CUMBERLAND
CITY COUNCIL

OA2024/0018

11 December 2024

Subject: Council Commentary regarding proposed Britton Street Multi-Level Warehouse (SSD-67368956)
Application No: OA2024/0018
Property: 15-21 Britton Street and 28- 54 Percival Road Smithfield.
Proposal: Demolition of existing Structures, clearing of vegetation, bulk earthworks construction and operation of two, 2 storey warehouses (Buildings A and B) and one 3 storey warehouse with ancillary uses such as office space, café or restaurant, end of trip facilities, shared amenities and 482 parking spaces on site.

TITLE	VEGETATION IMPACT	PROJECT NO.	22144	DWG NO.	DA121	REVISION	11
DATE	22.10.2024	SCALE

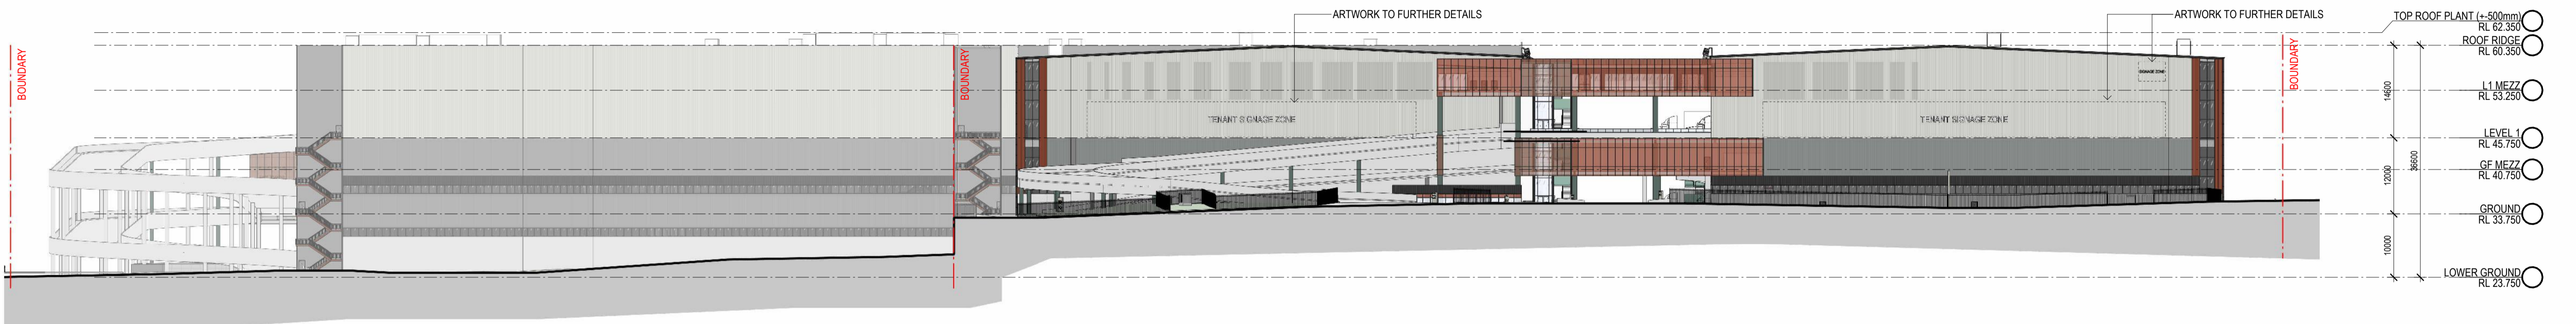
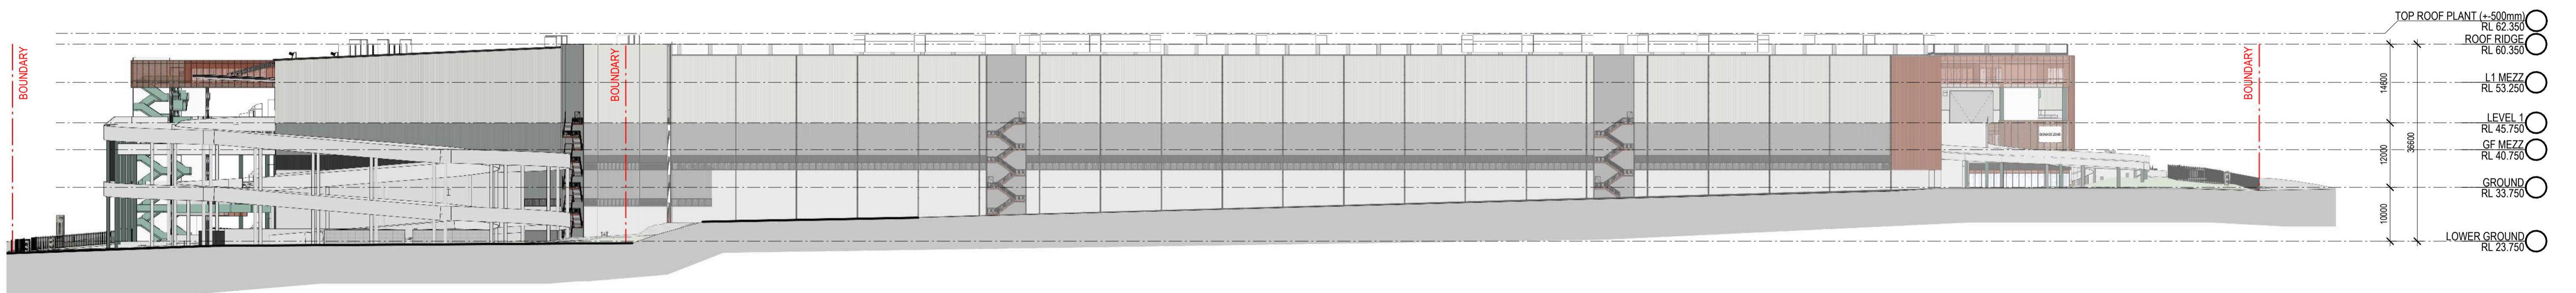
The application also proposes a large amount of vegetation removal from the site for the proposed development. Given the proposed building development bulk and scale, it would be encouraged to provide additional landscaping and planation on the site.

Applicant should ensure that compliance with the Biodiversity Offset Scheme is achieved. It is noted that the applicant has obtained a Biodiversity Development Assessment Report however it does not state whether the scheme has been triggered due to the large number of trees proposed for removal on the site.

Due to the high number of trees requiring removal under this proposal and given the large nature of the combined sites, the applicant should ensure that sufficient replacement planting occurs to ensure where possible, the removal of the trees is offset with supplementary suitable advance plantings.
